RE: South Academy Business Center  
Response Letter

Please see our response to the comments received on February 15, 2018.

DRAINAGE, GRADING & EROSION CONTROL COVER

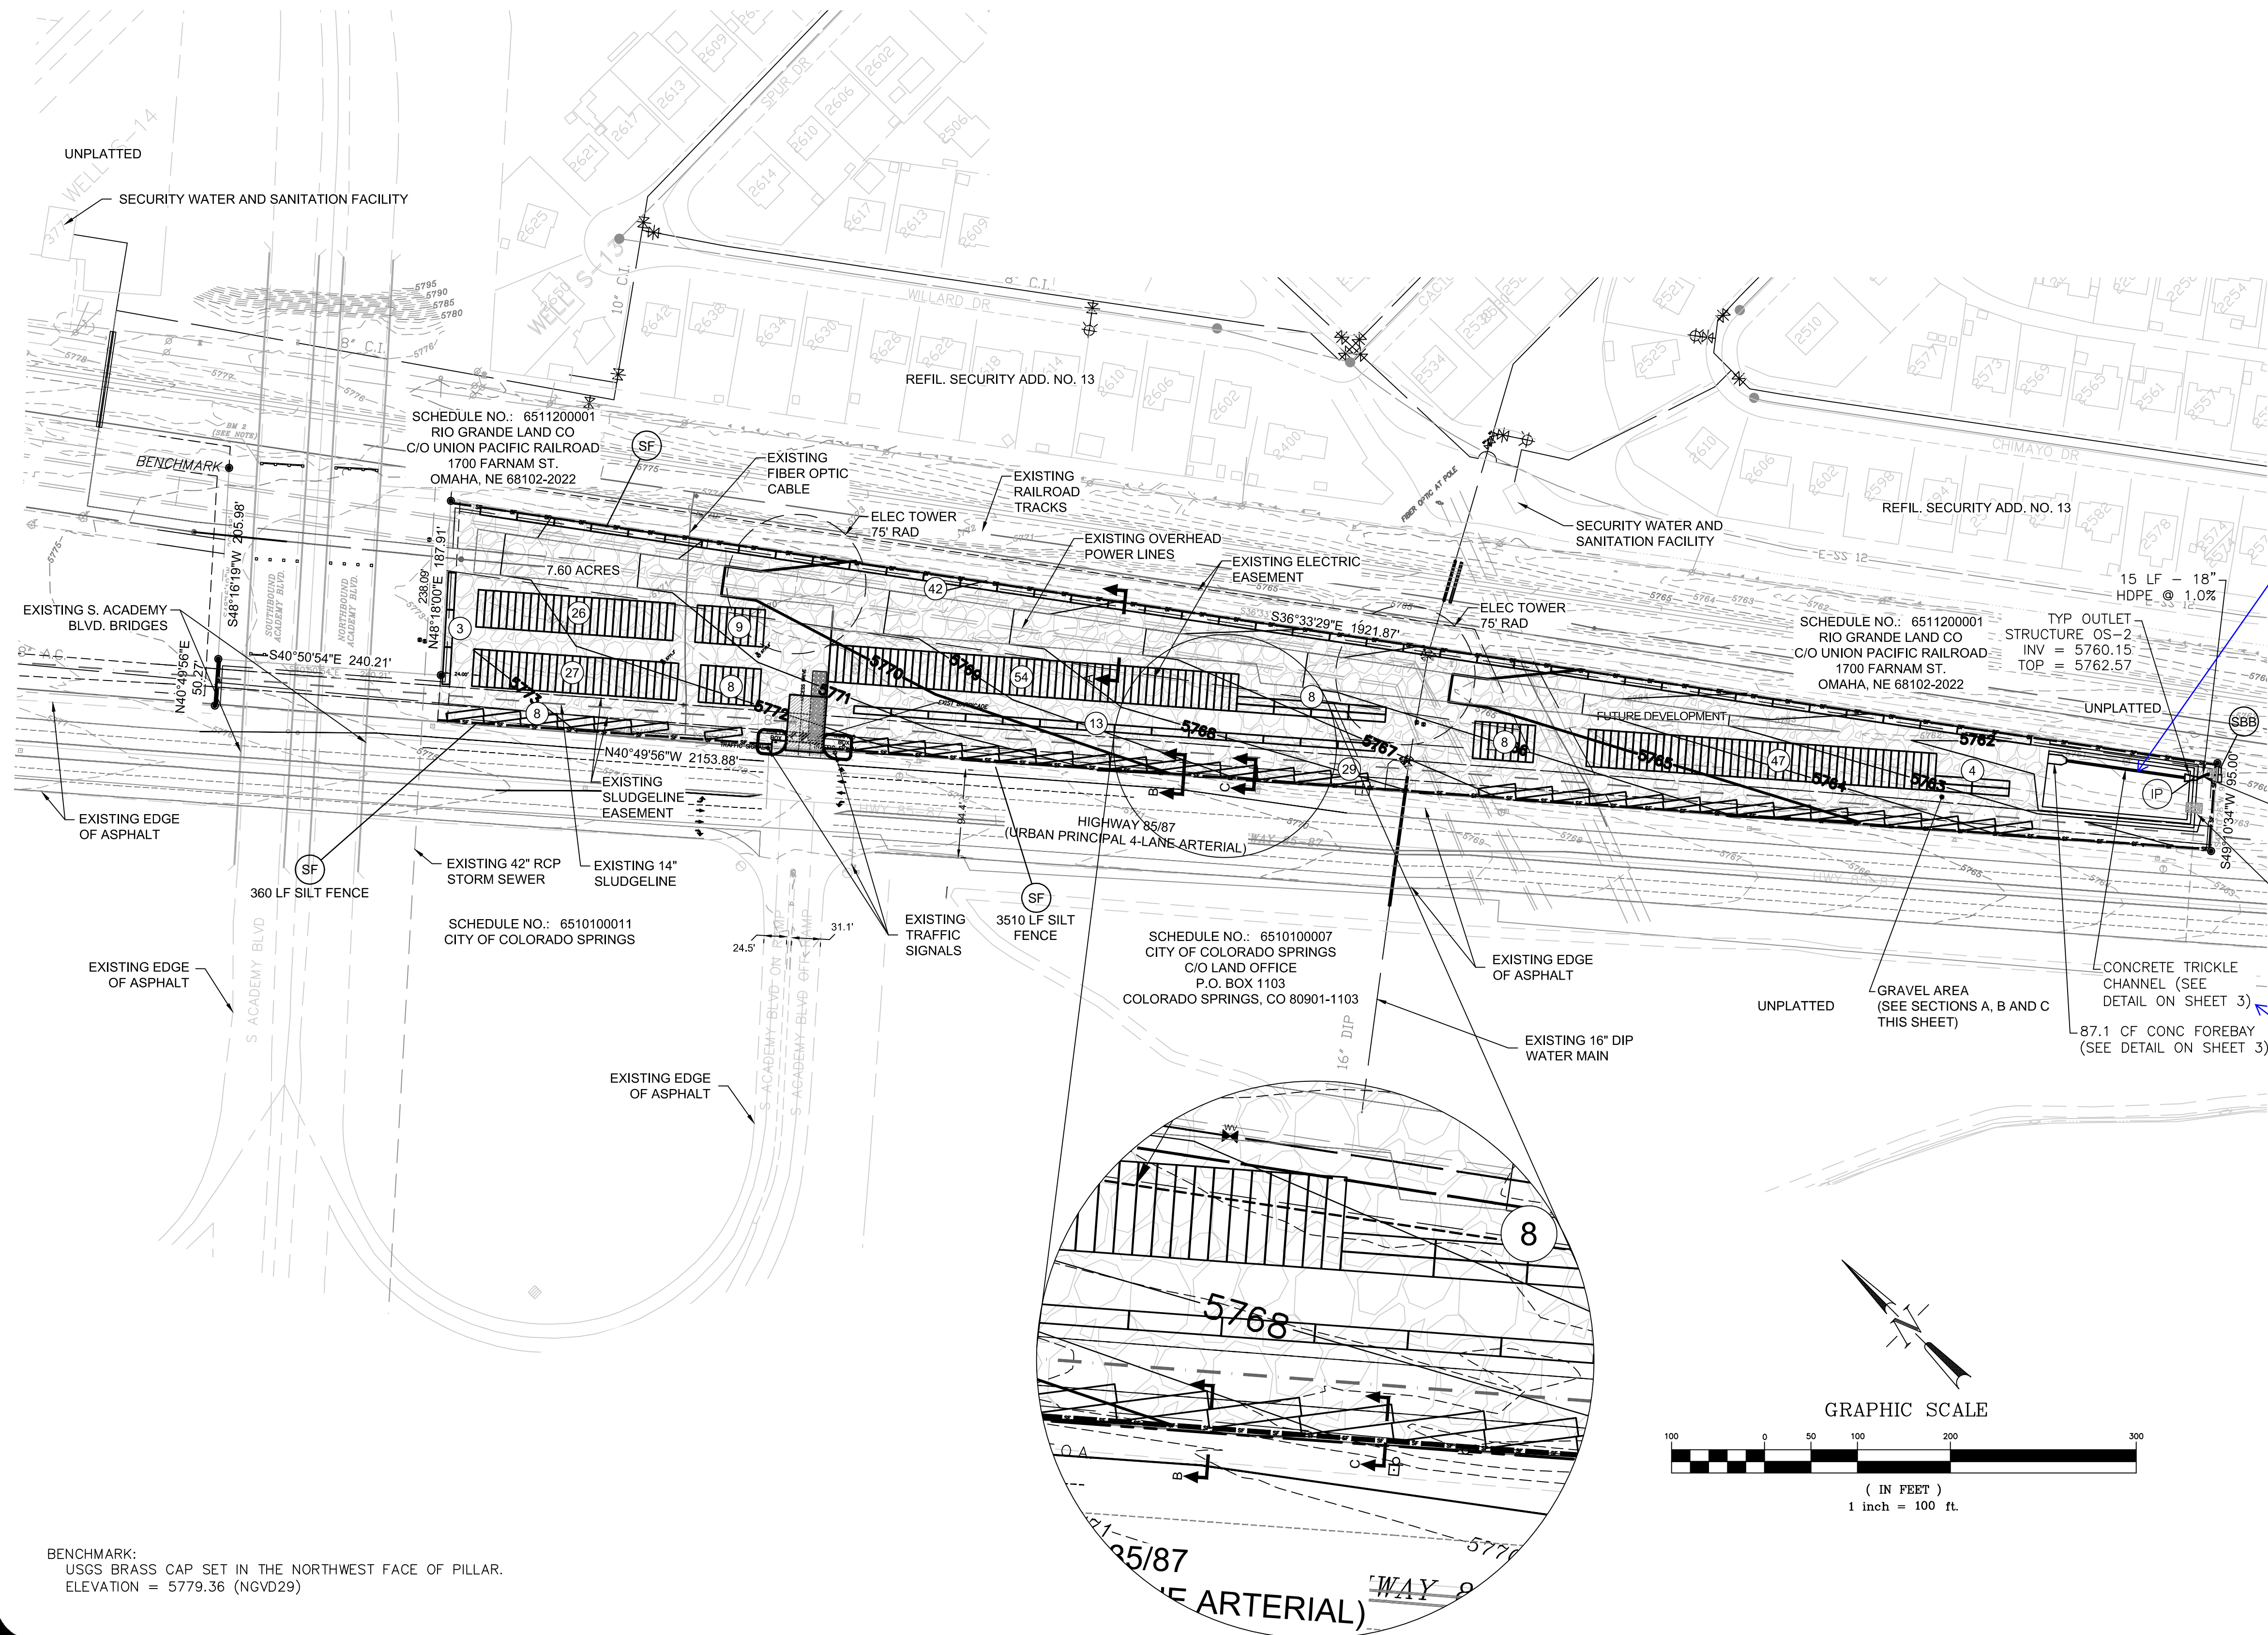
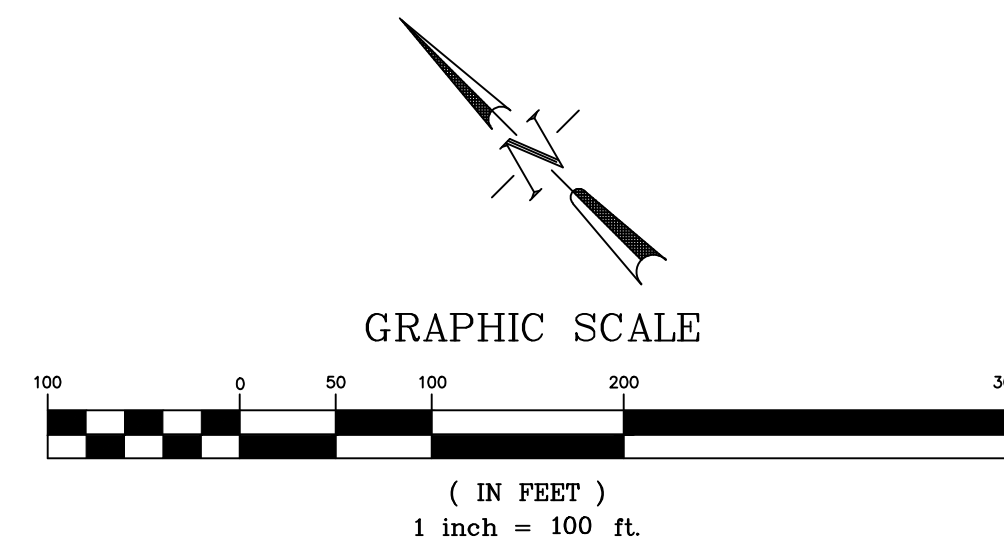
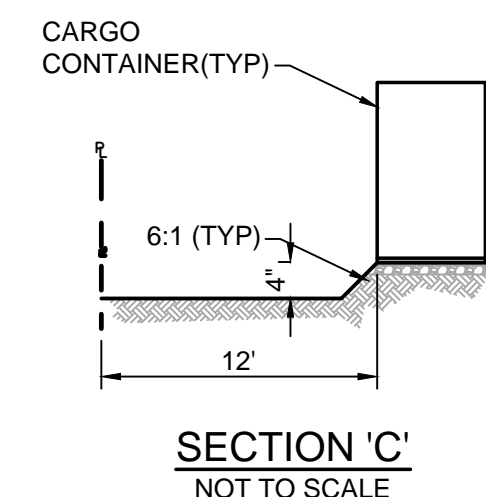
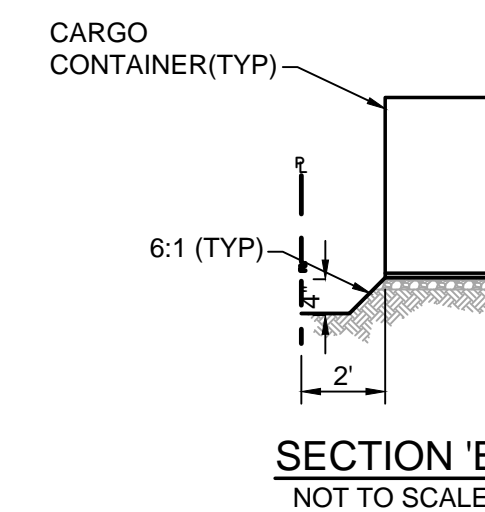
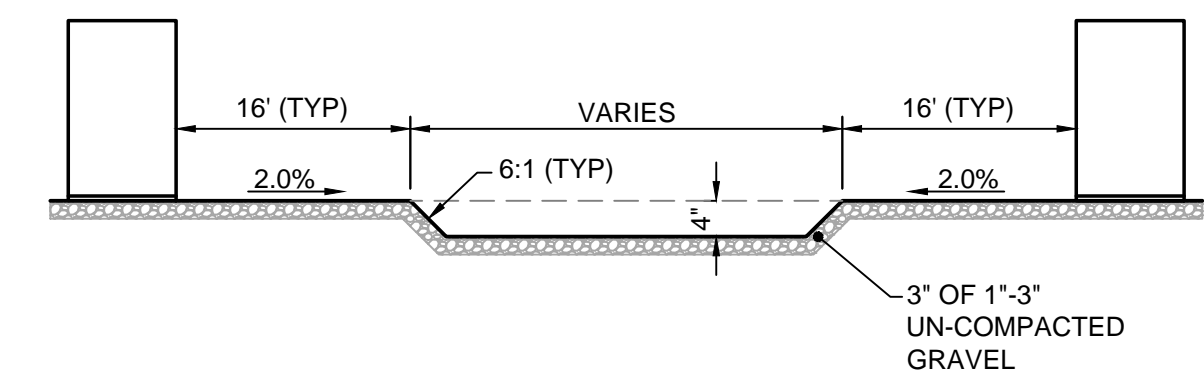
- Financial assurances have been updated.
- A temporary sedimentation basin was added
- The slope of the trickle channel was added

OUTLET STRUCTURES DETAILS

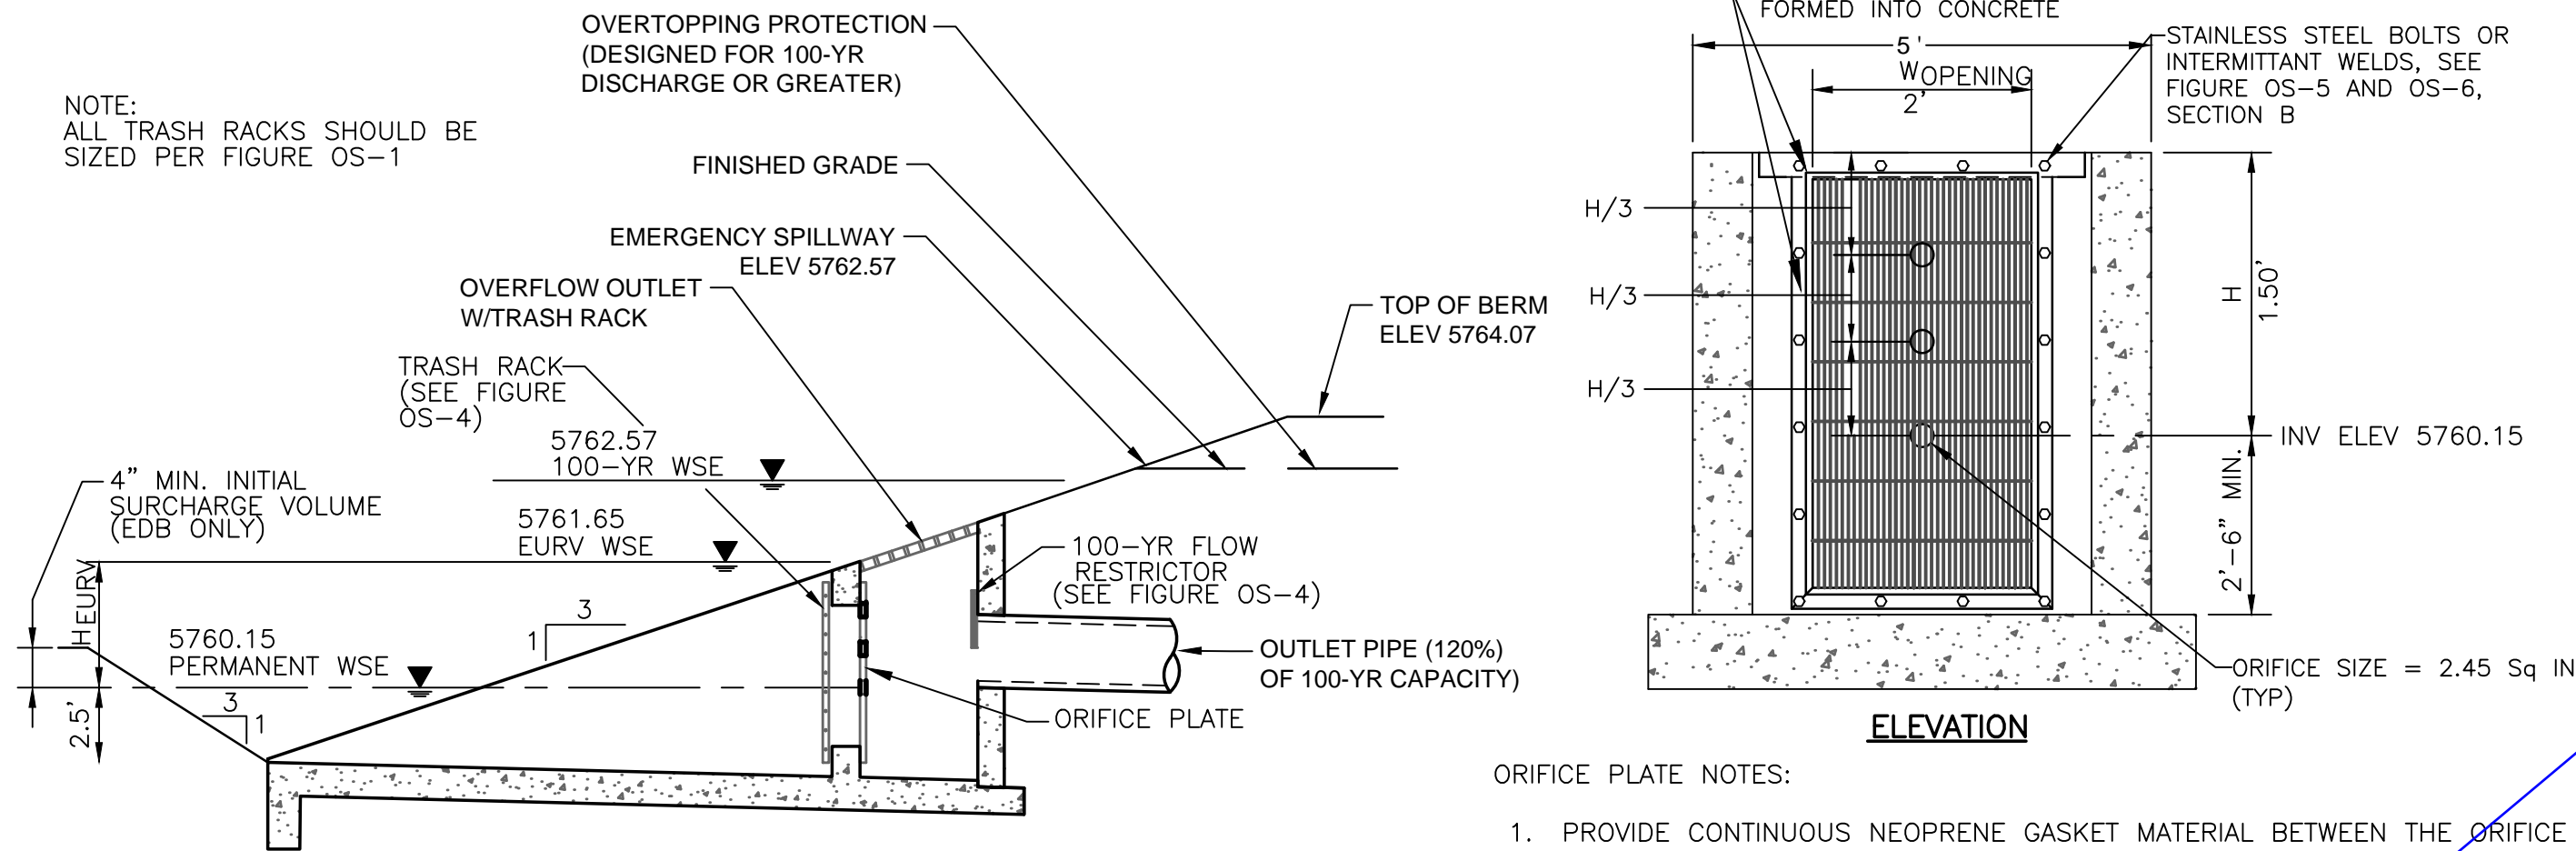
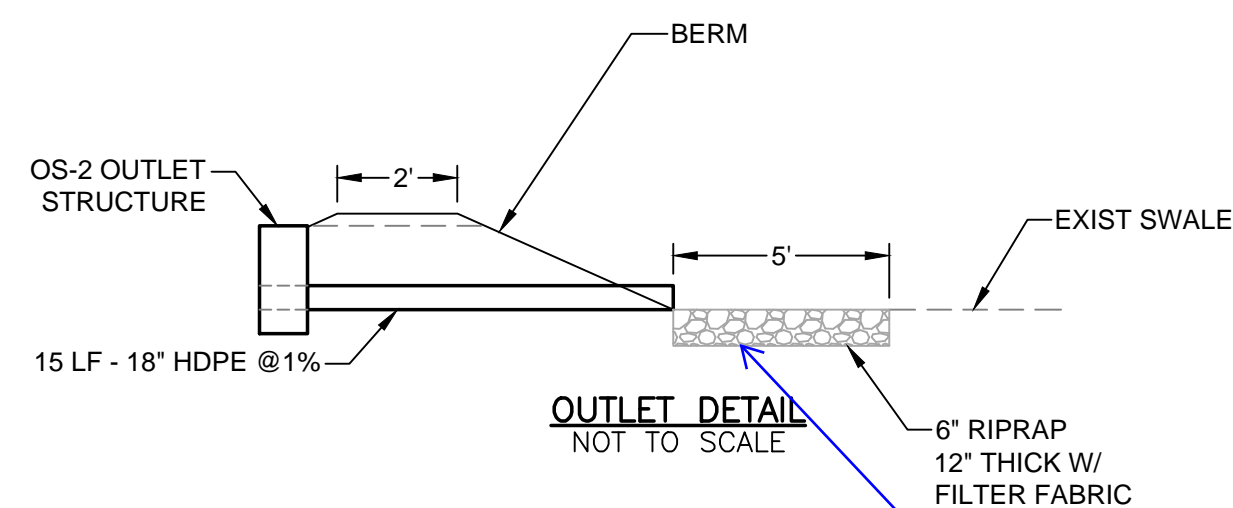
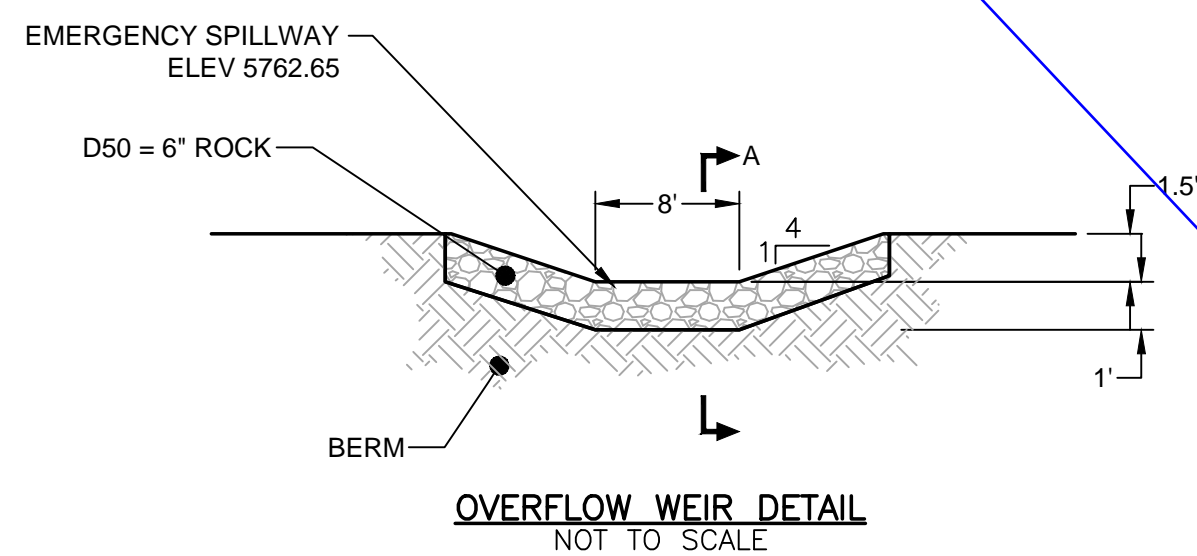
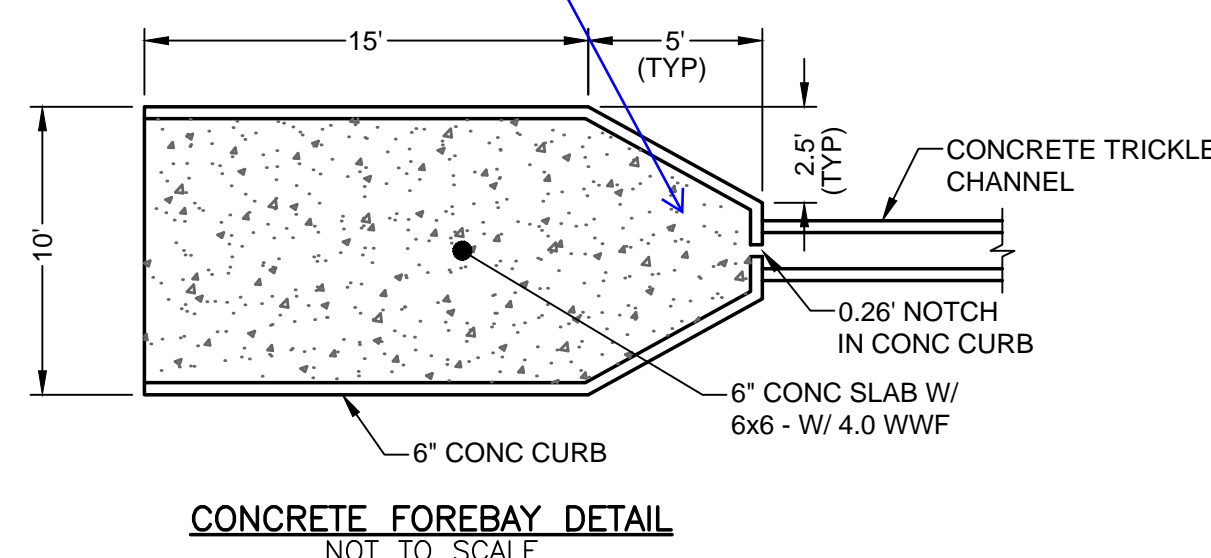
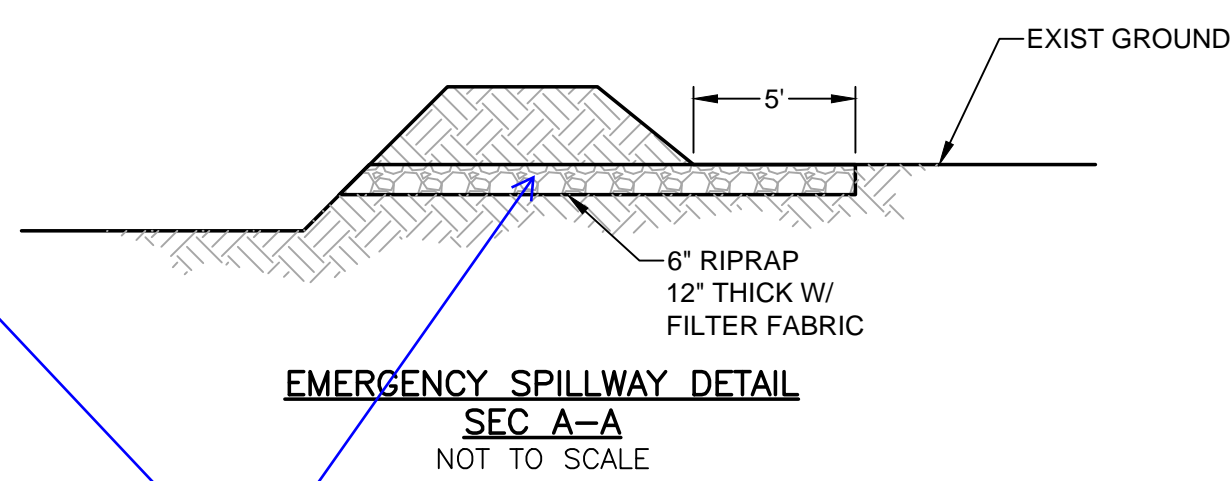
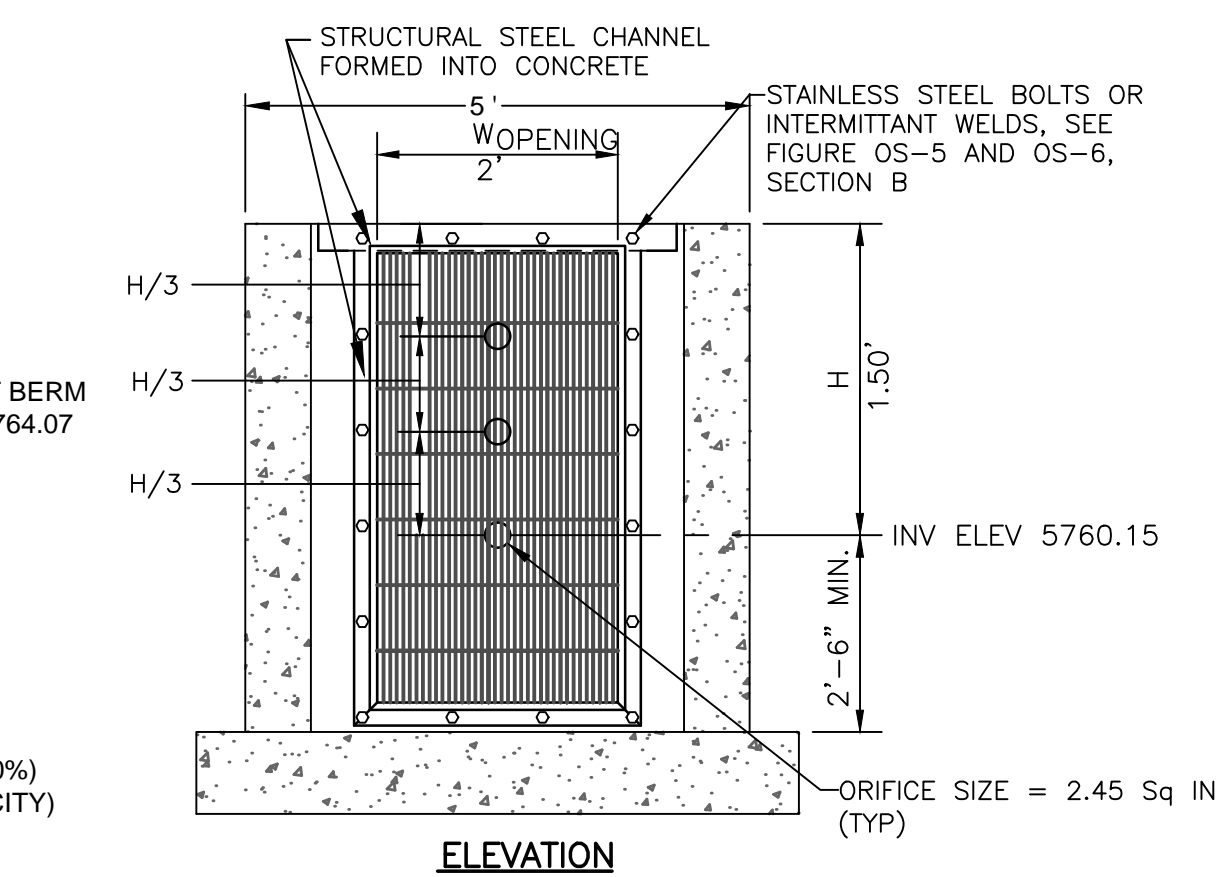
Comments have been addressed and an addition sheet was added to clarify how the structures related to the rest of the pond.
